THE SOD GUY - SALES LOT

SITE DEVELOPMENT PLANS
LOT 1, APPALOOSA HIGHWAY 24 SUBDIVISION

Site Development Plan_v1-redline.pdf Markup Summary

THE SOD GUY - SALES LOT
SITE DEVELOPMENT PLANS
LOT 1, APPALOOSA HWY 24 SUBDIVISION FILING NO 1A

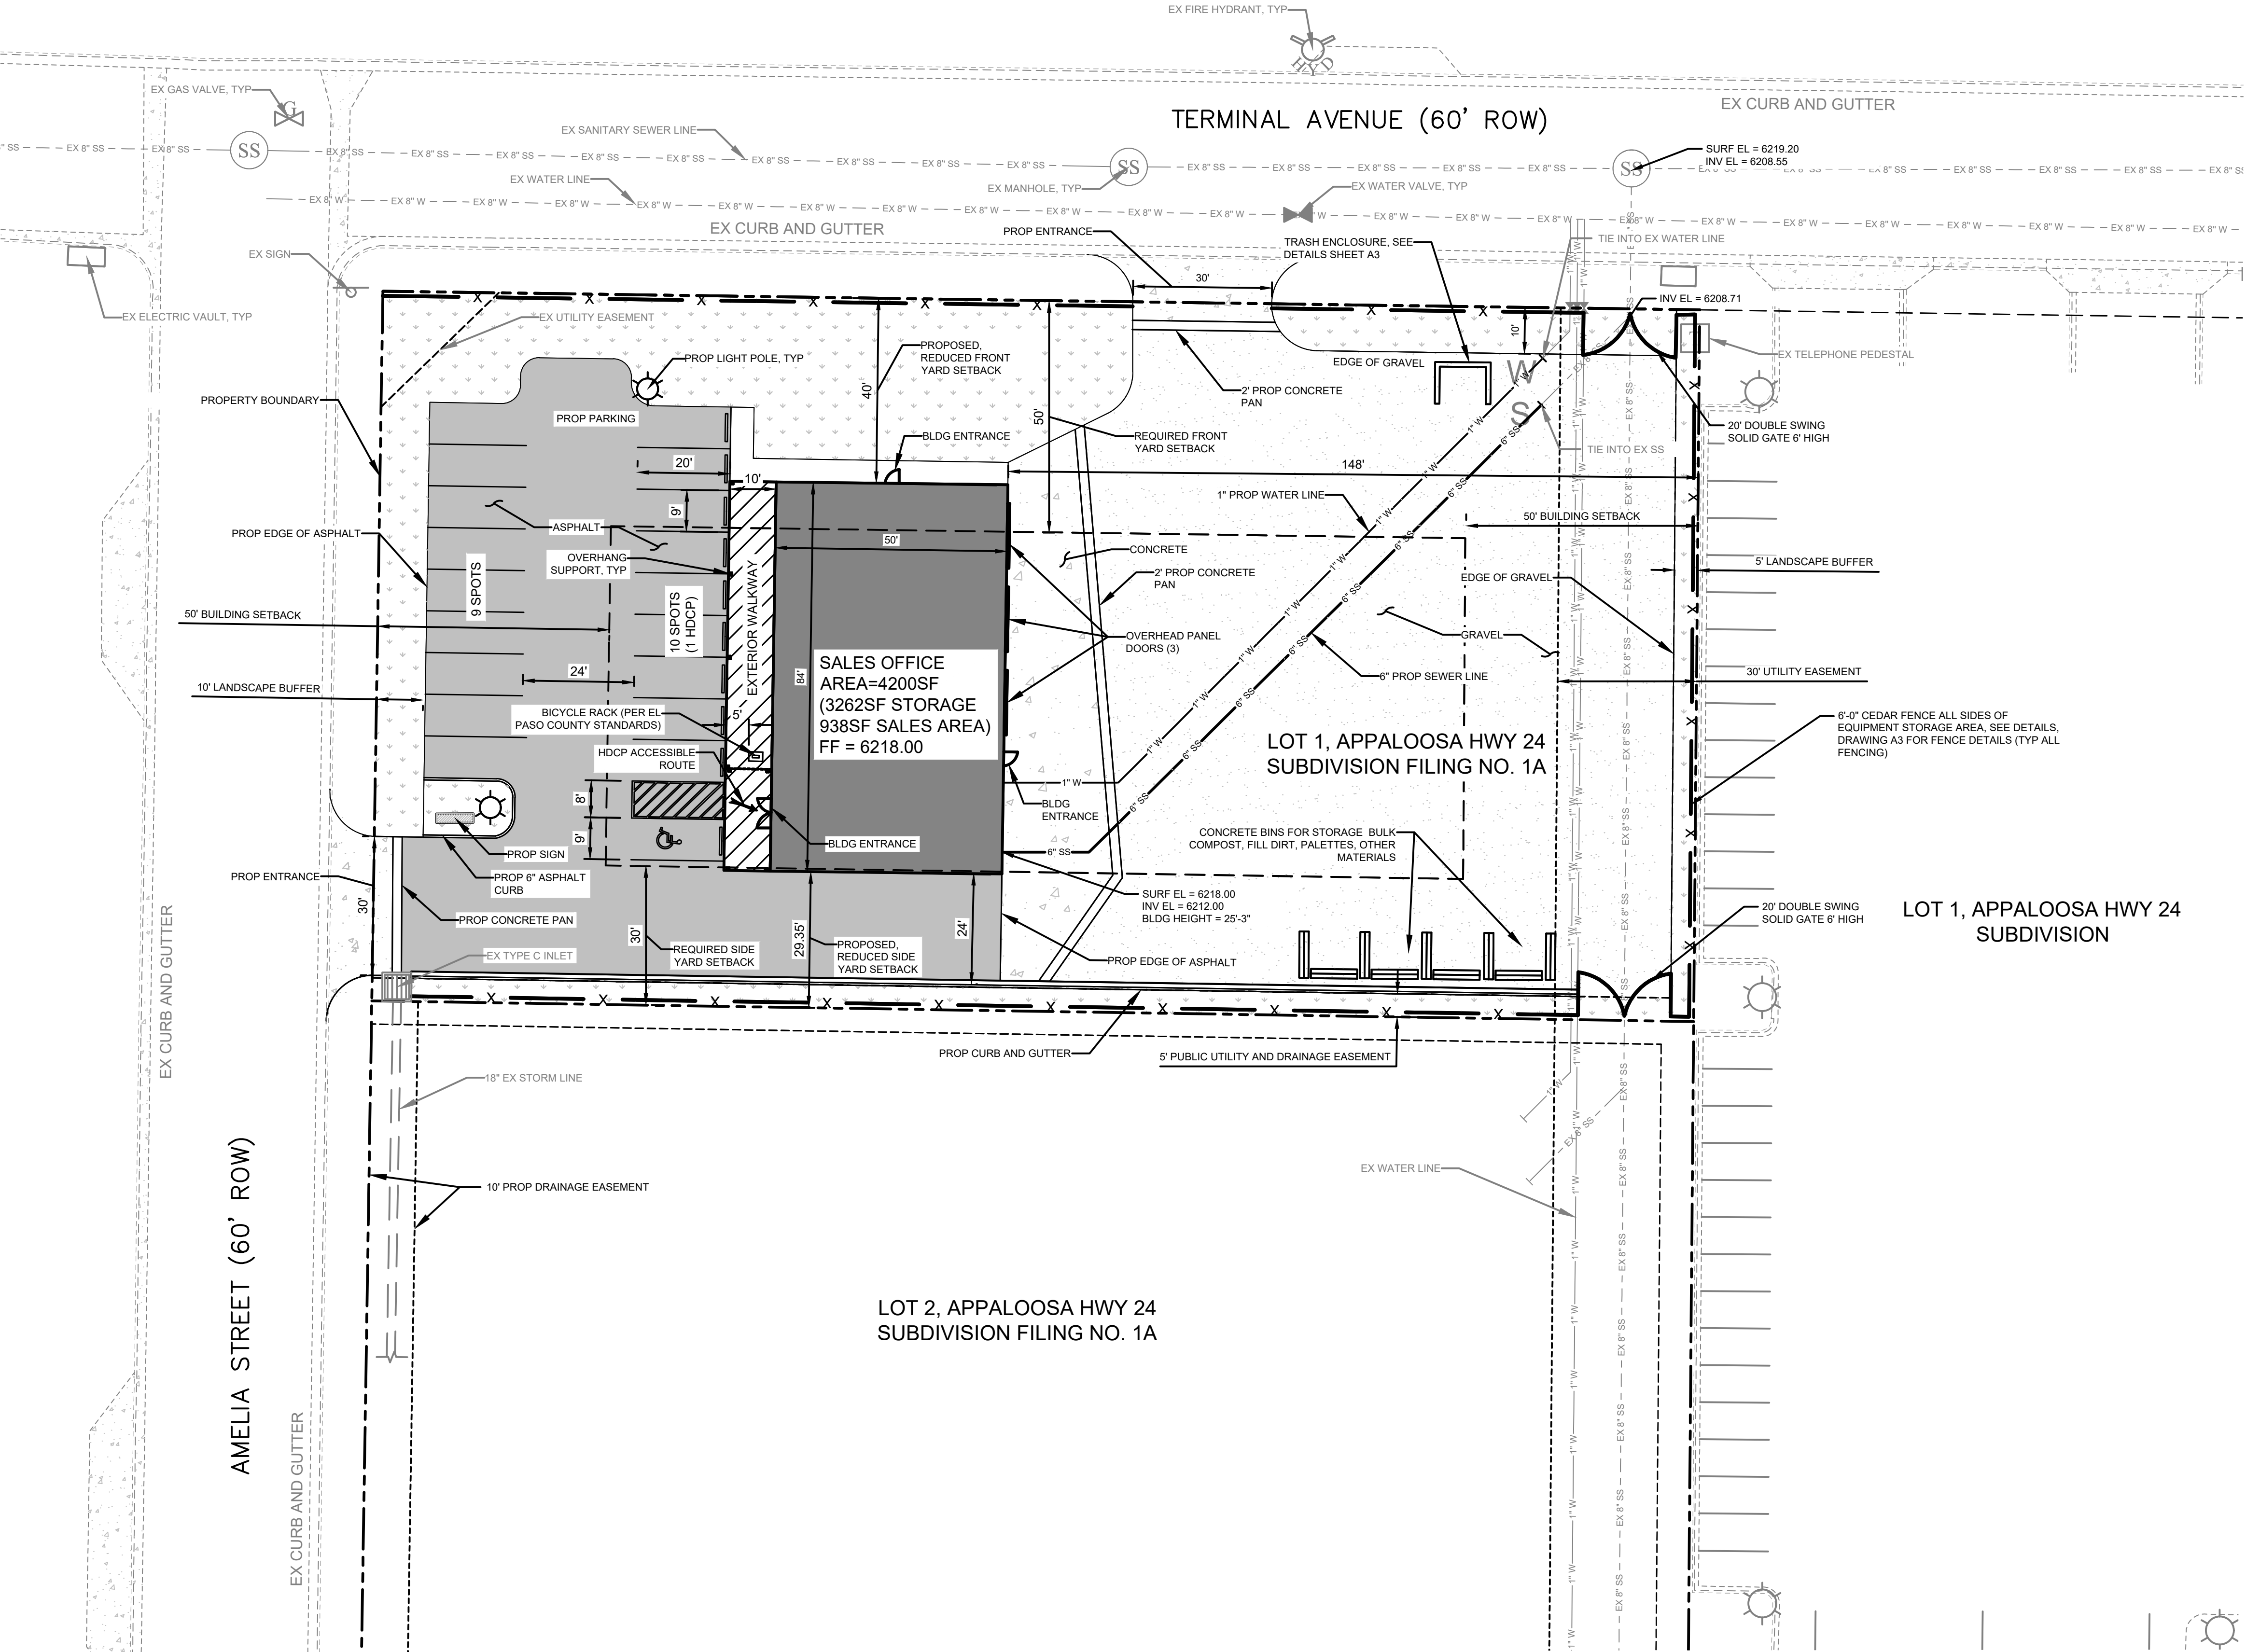
See comments from special use/administrative relief. The front yard setback applies to any nonresidential frontage with an access.

Show landscaping calculations on the landscape plan.

Show parking calculations from Table 6.2 and 6.3 in this area.

Is this the only storage area?

TRASH ENCLOSURE WALL SECTION
 SCALE: 3/4" = 1'-0"
 0" 6" 12" 24"

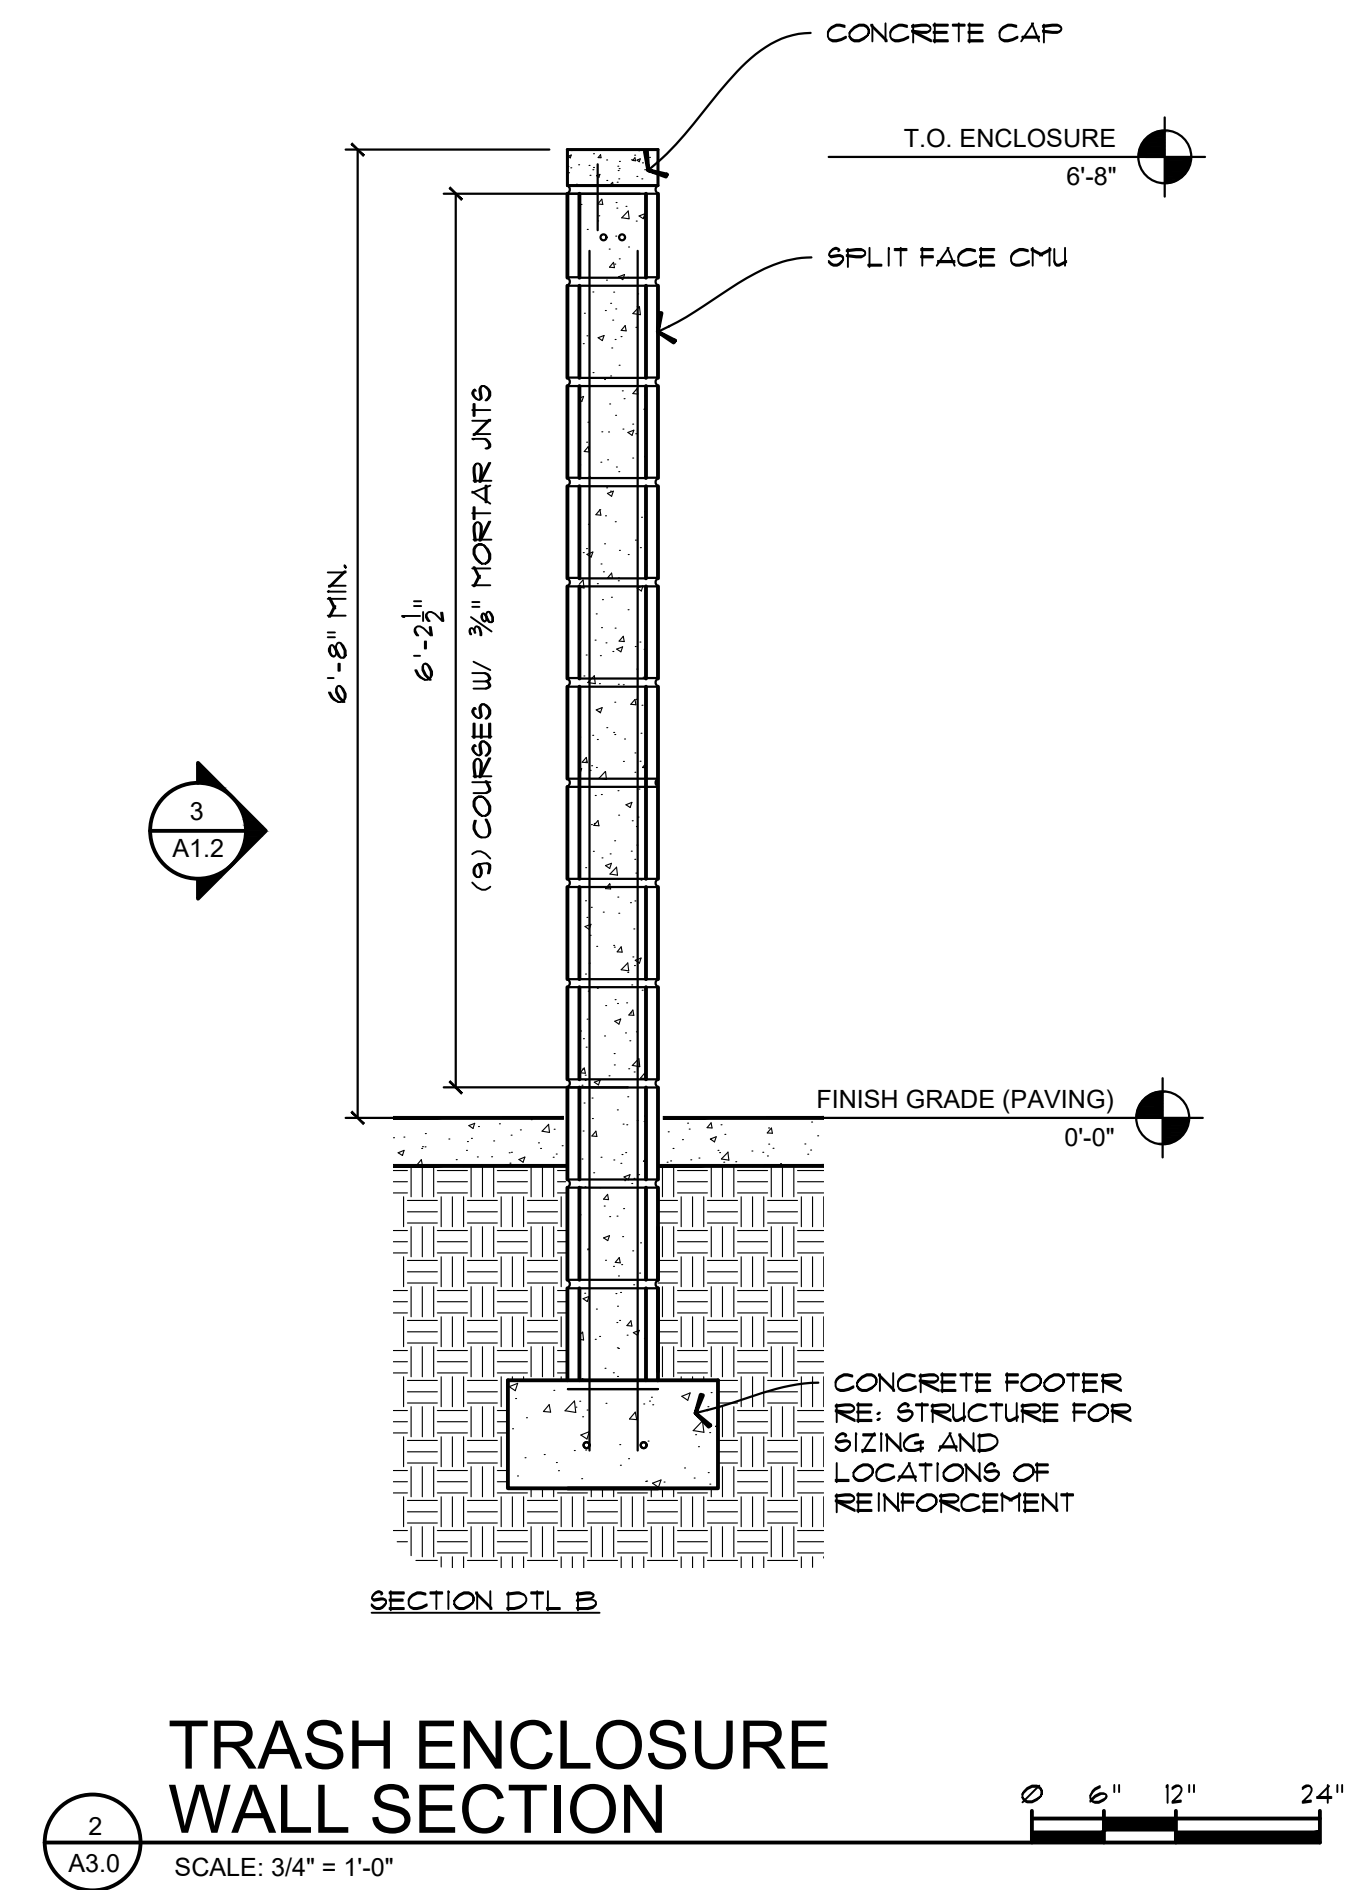
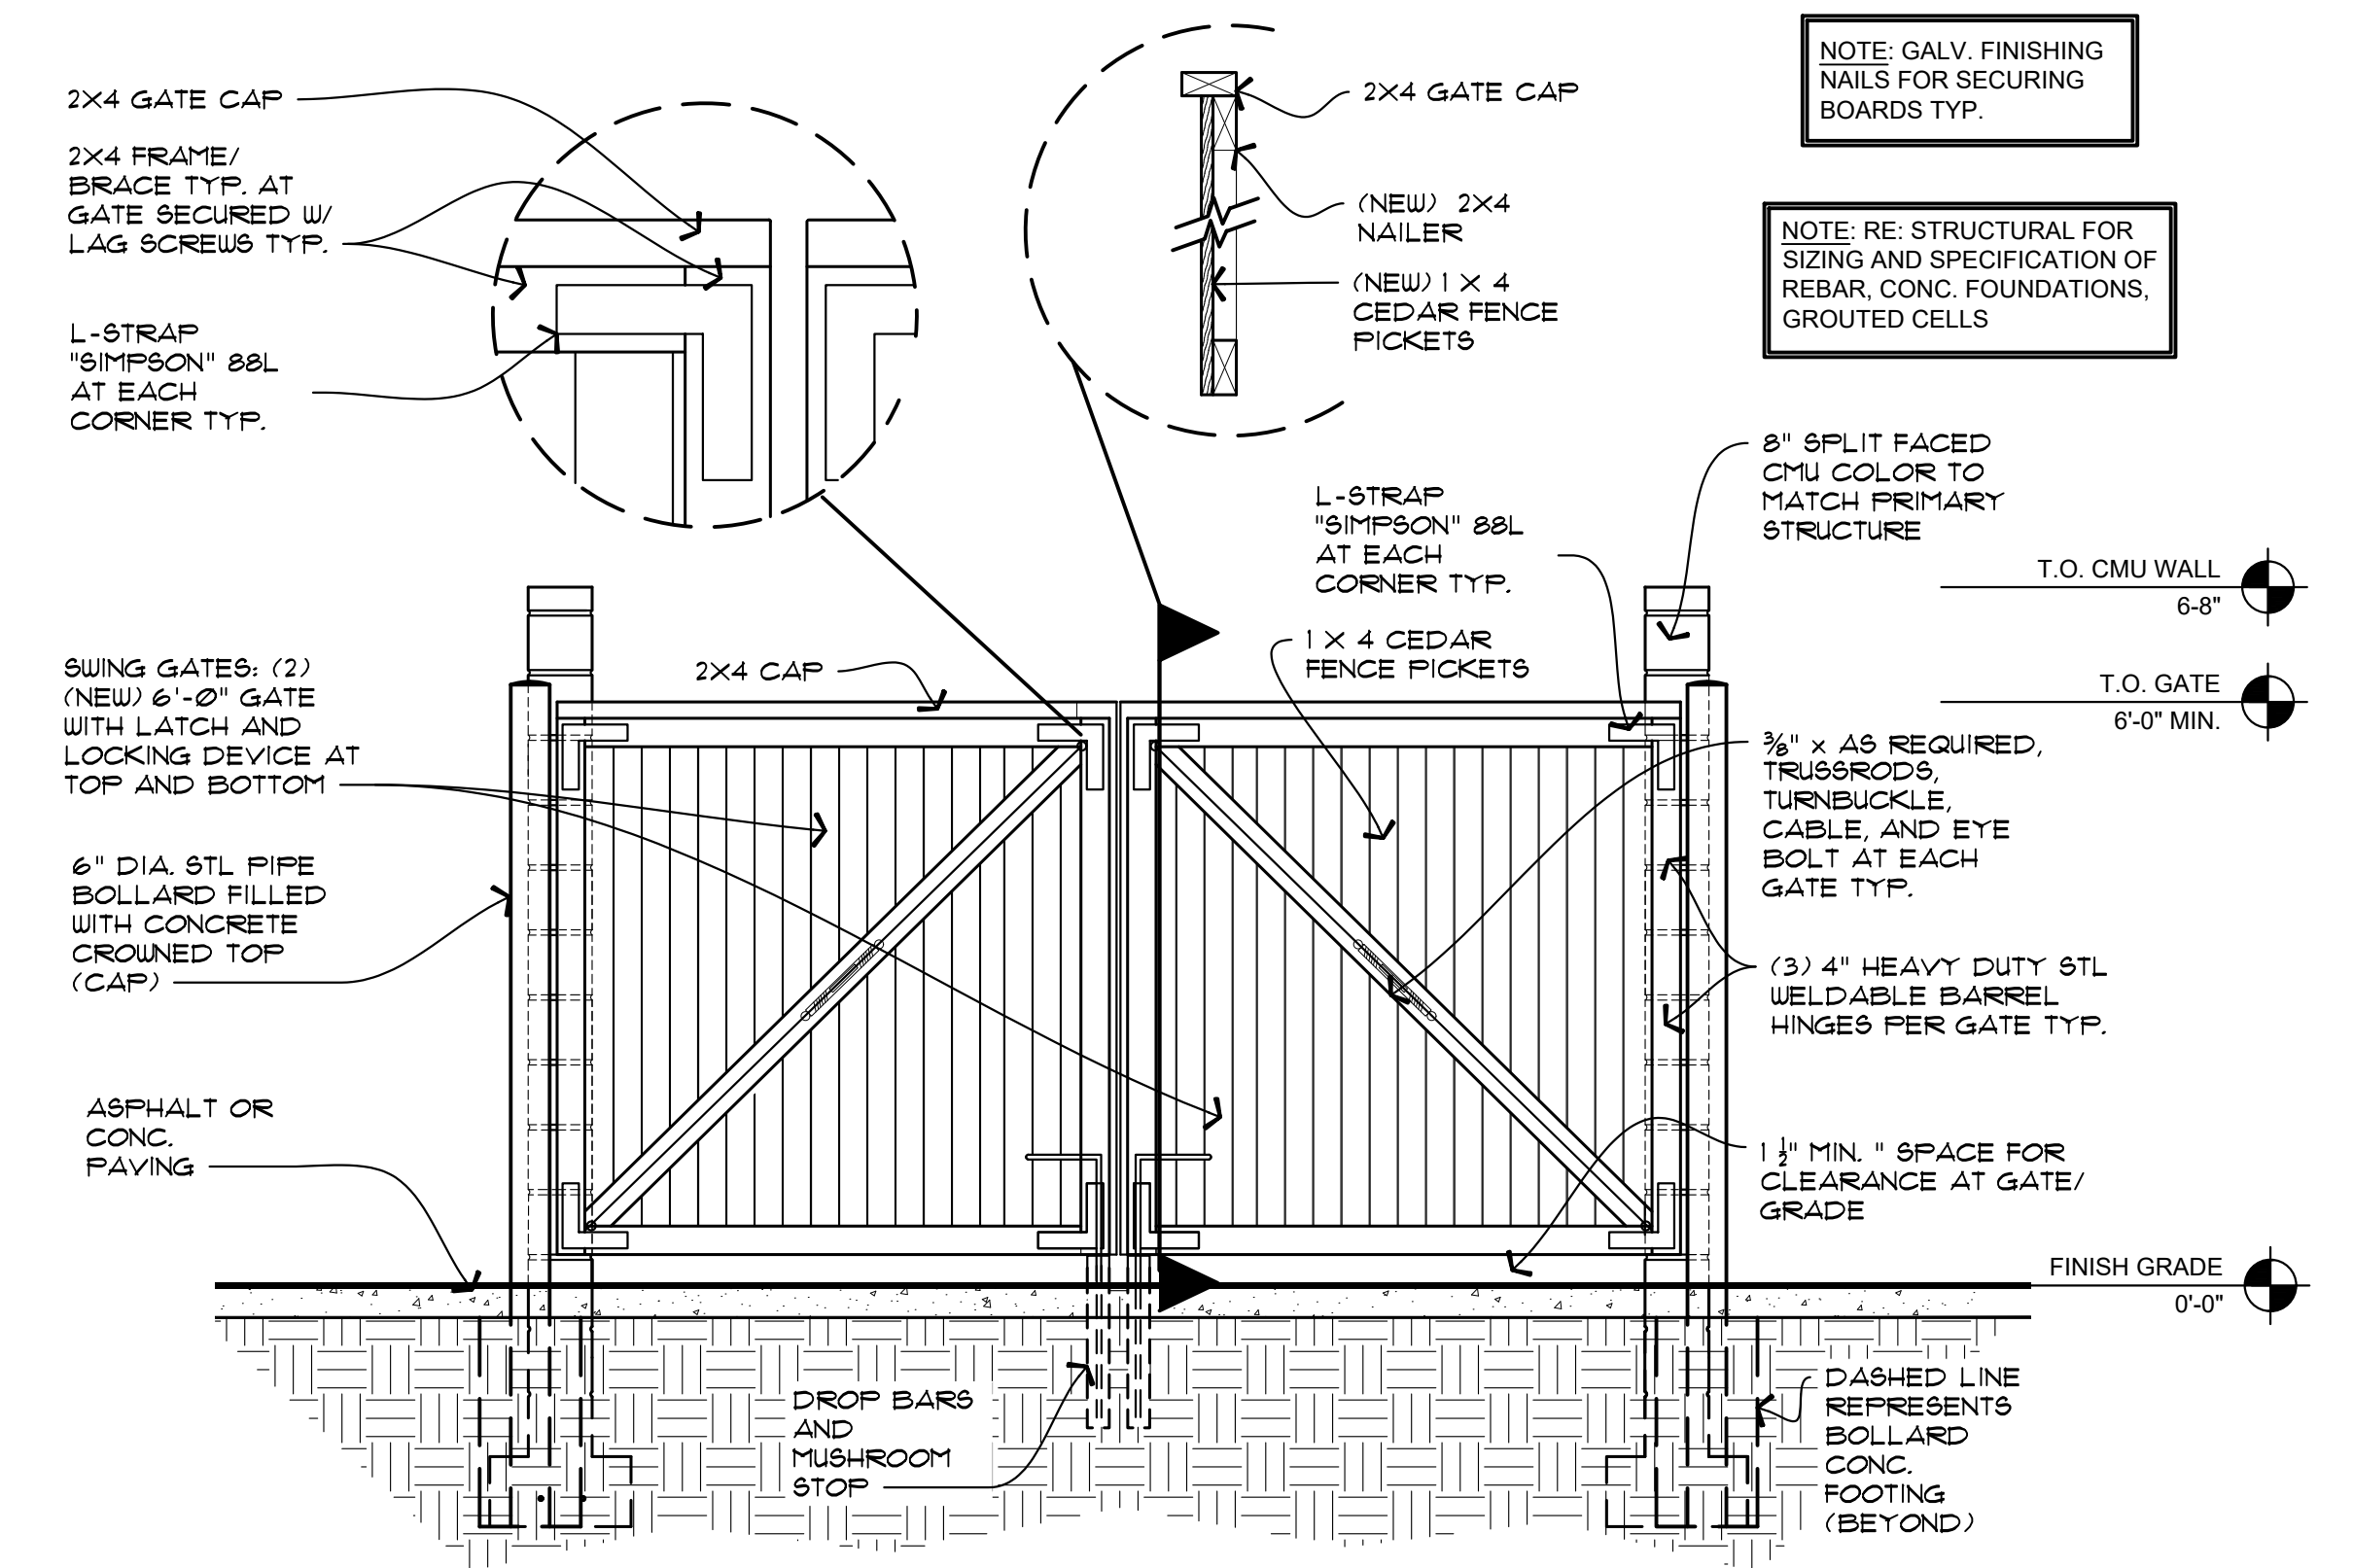
Show fence detail.

Show trash enclosure and detail.
